From: [REDACTED]
To: [Sunnica Energy Farm](#)
Subject: Additional comments regarding closure of 204/5
Date: 12 March 2023 14:48:14
Attachments: [image001.png](#)
[sunnica questionnaire.docx](#)

Icknield Way Bridleway Snailwell – impact of Sunnica proposal

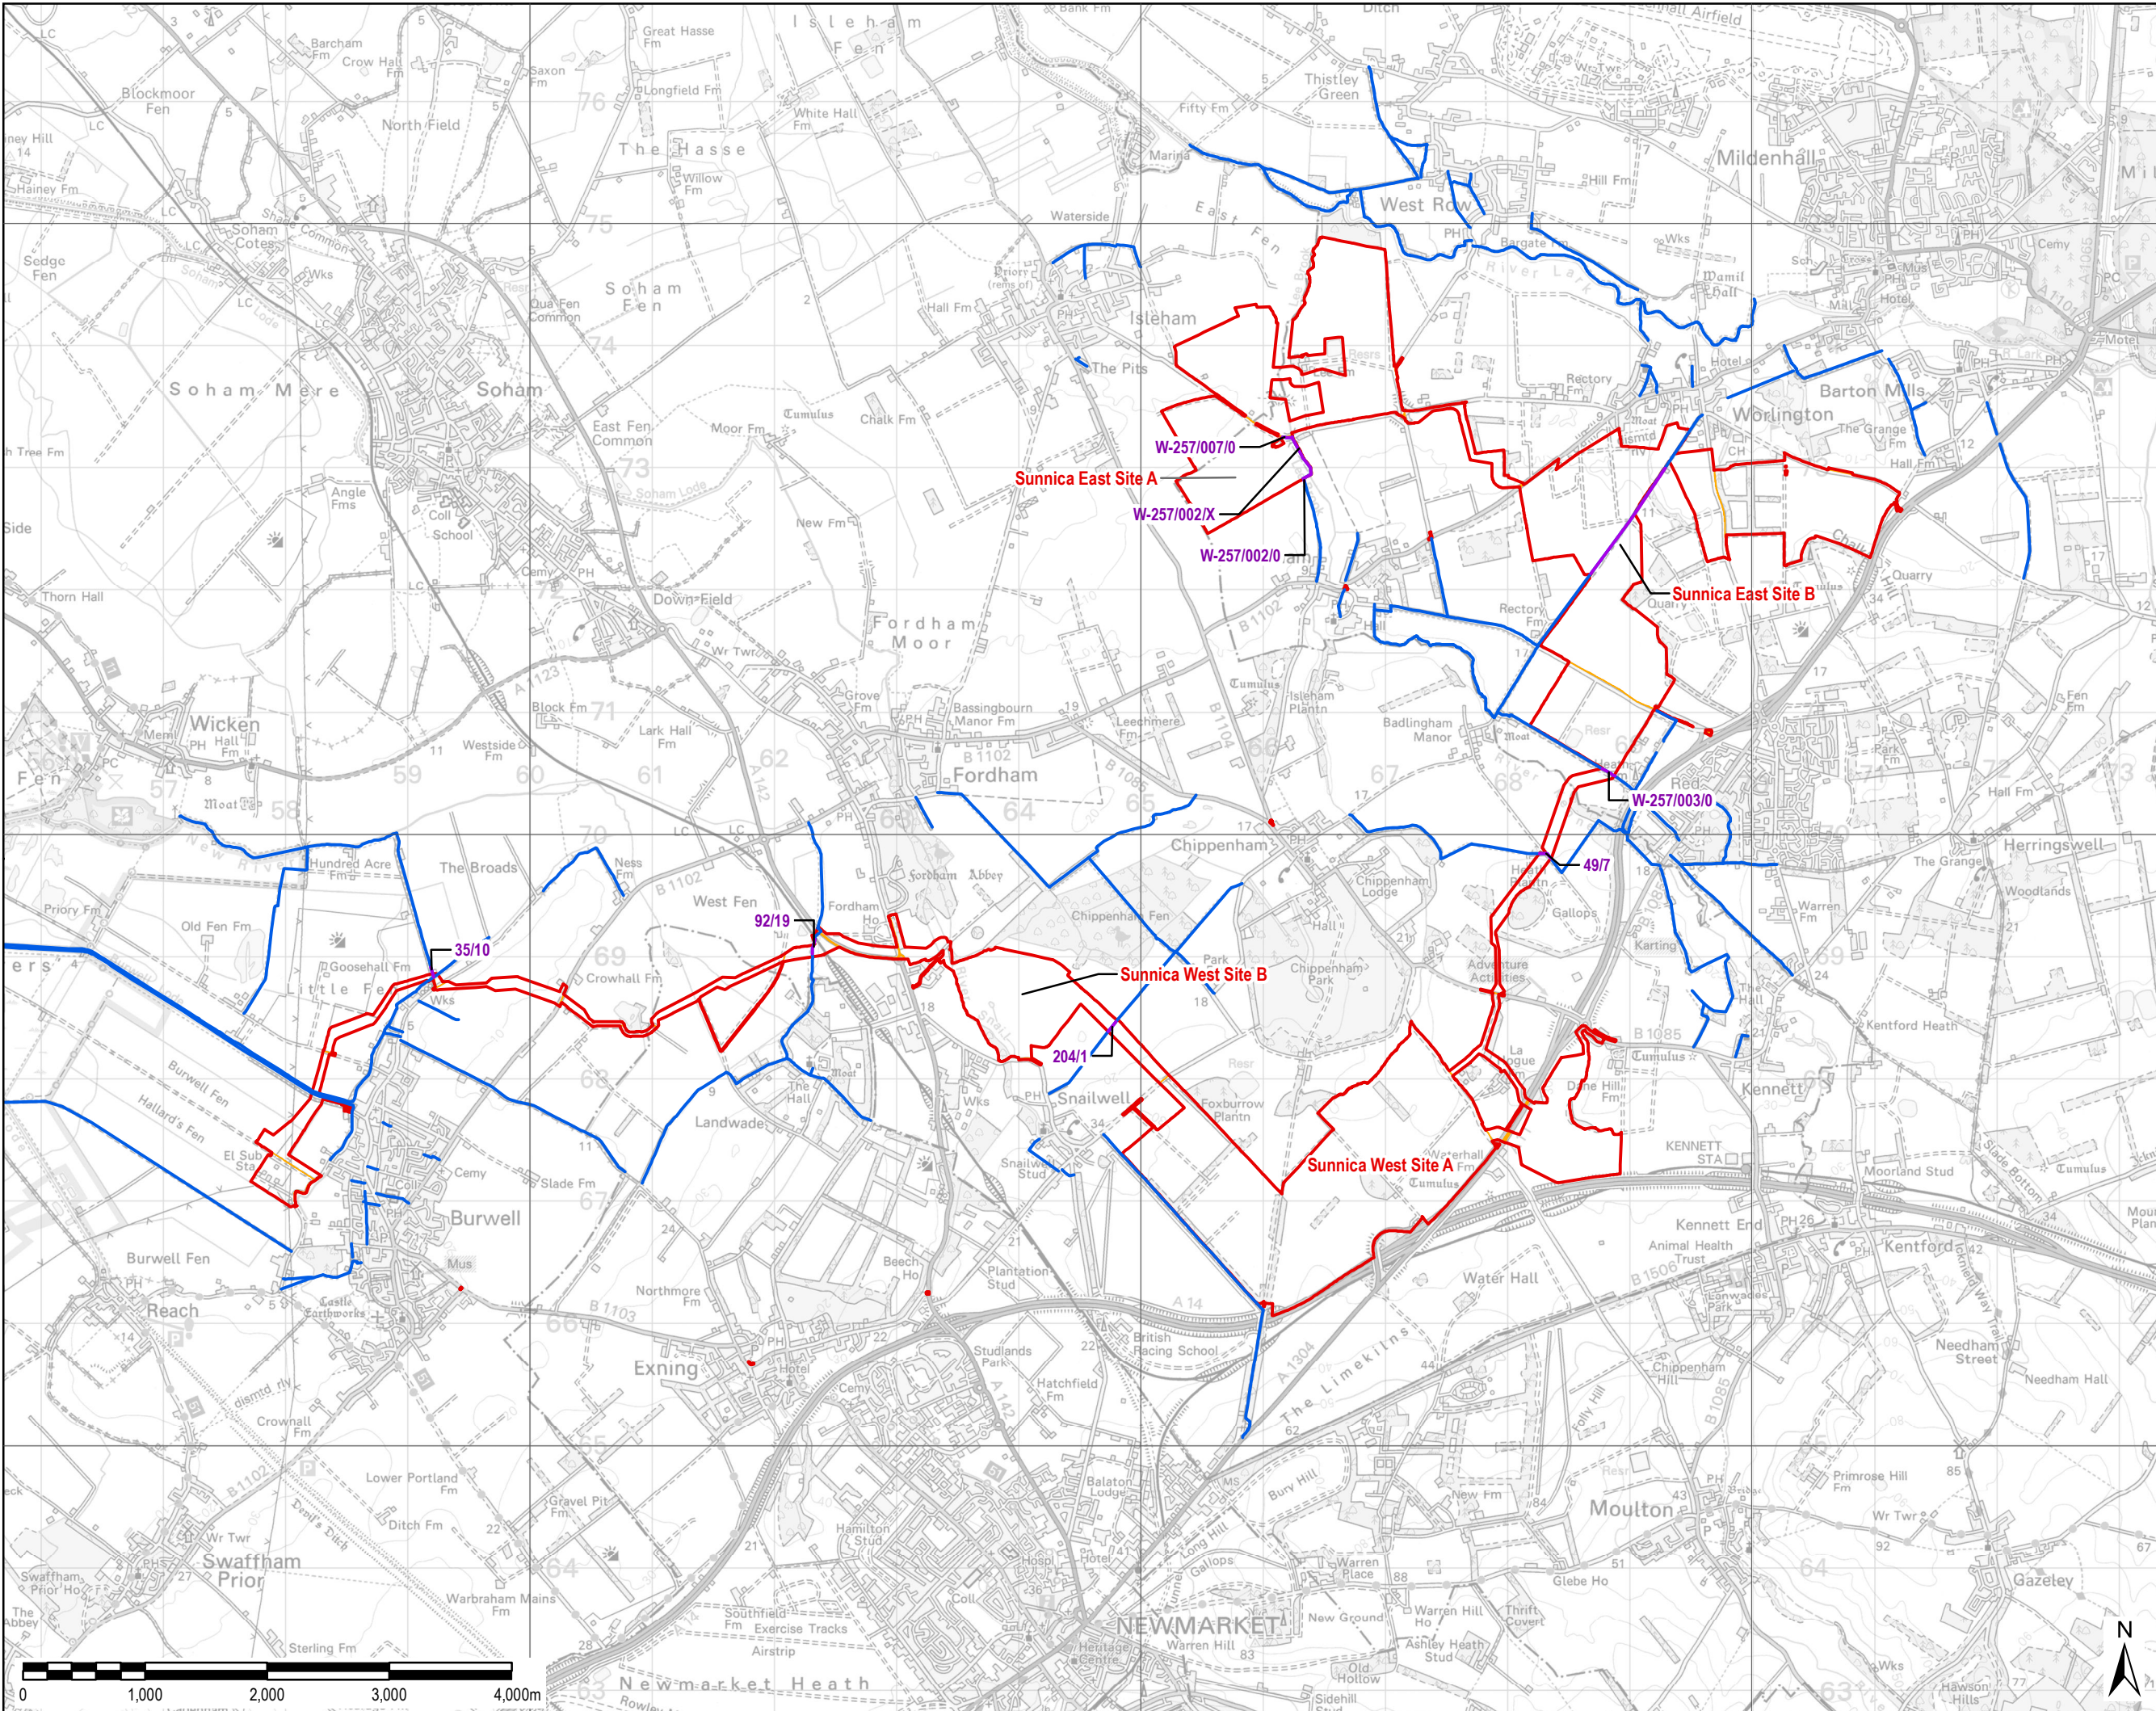
The Icknield Way is known in the various Sunnica documents as 204/5. Appendix 13A, Sub Chart E of the Provisional Environmental Impact Report (PEIR), states that this Right of Way is to be closed along the greater part of its length for the entire duration of the construction phase of about two years.

The Sunnica Plans call for the Icknield Way to be closed for two years. No reason is given for this. The path does not lie within the boundary of the scheme and no access to the scheme is proposed which requires the use of it. Based solely on the Sunnica documents, I see no reason to close it at all. However, I can imagine there may be short periods of time during which closure becomes

necessary for safety reasons and I would ask that any such closure be restricted to the affected part of the path and be for the minimum length of time necessary.

I ask Sunnica to reconsider the status of 204/5 and to ask if closure is really necessary. If it is, then I would ask that the closure be only for short periods when construction requires it, and not for the duration of the construction phase.
